**Laurie Leader - RE: Example code analysis**

**From:** "Mark D. Lee" <mlee@harriman.com>  
**To:** Laurie Leader <LRL@portlandmaine.gov>  
**Date:** 2/19/2015 3:35 PM  
**Subject:** RE: Example code analysis  
**CC:** "John A. Ellis" <jellis@harriman.com>

**From:** Laurie Leader [mailto:LRL@portlandmaine.gov]  
**Sent:** Friday, February 13, 2015 9:48 AM  
**To:** Mark D. Lee  
**Cc:** John A. Ellis  
**Subject:** Re: Example code analysis

CODE PLAN

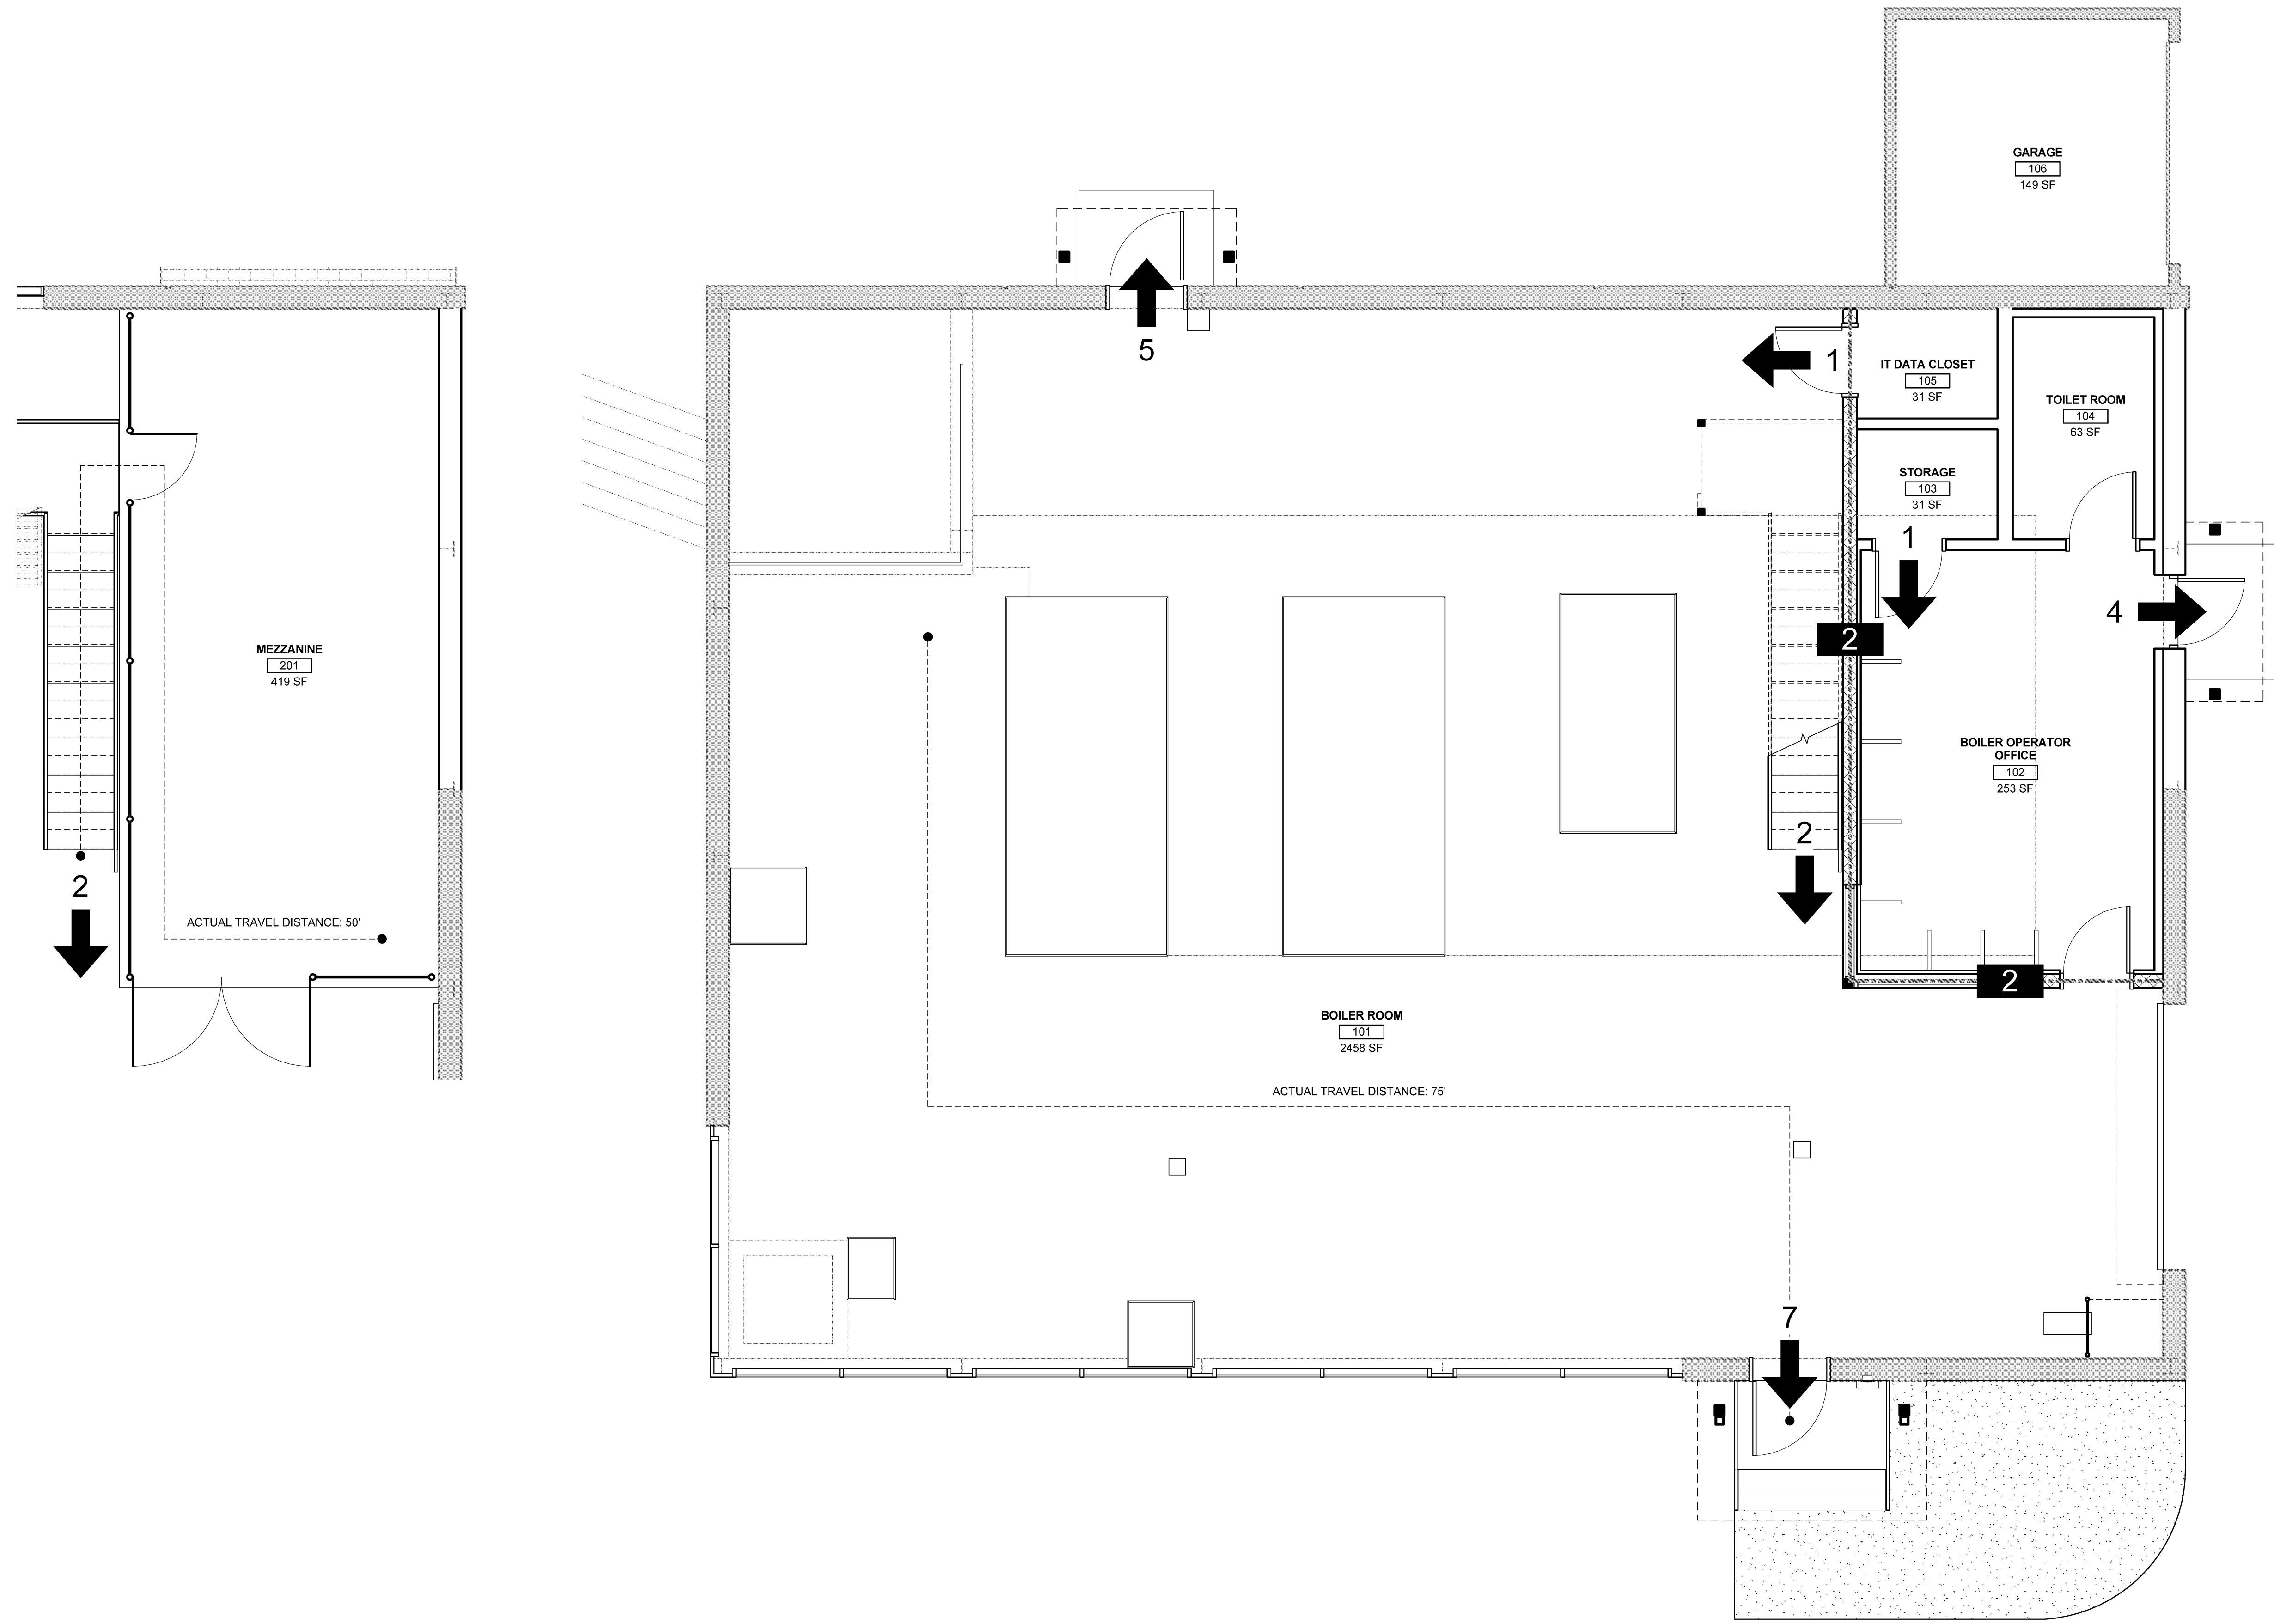
Thanks for stopping in yesterday. Can you add your occupant load to the code analysis. Once I have that, I am just about ready to sign off on this. I am checking with planning to see if we need an administrative authorization as well. Hopefully I will know if an administrative authorization is required within the next day or so.

Utility/Accessory/Mechanical: 300 SF/Occupant

Mezzanine: (419 SF) = 2 occupants

Boiler Room: (2,458 SF) = 9 occupants

Storage Room (31 SF) = 1 occupant

IT Data Closet (31 SF) = 1 occupant

Office: 100 SF/Occupant

Boiler Operator Office (253 SF) = 3 occupants

Total Occupants: 16
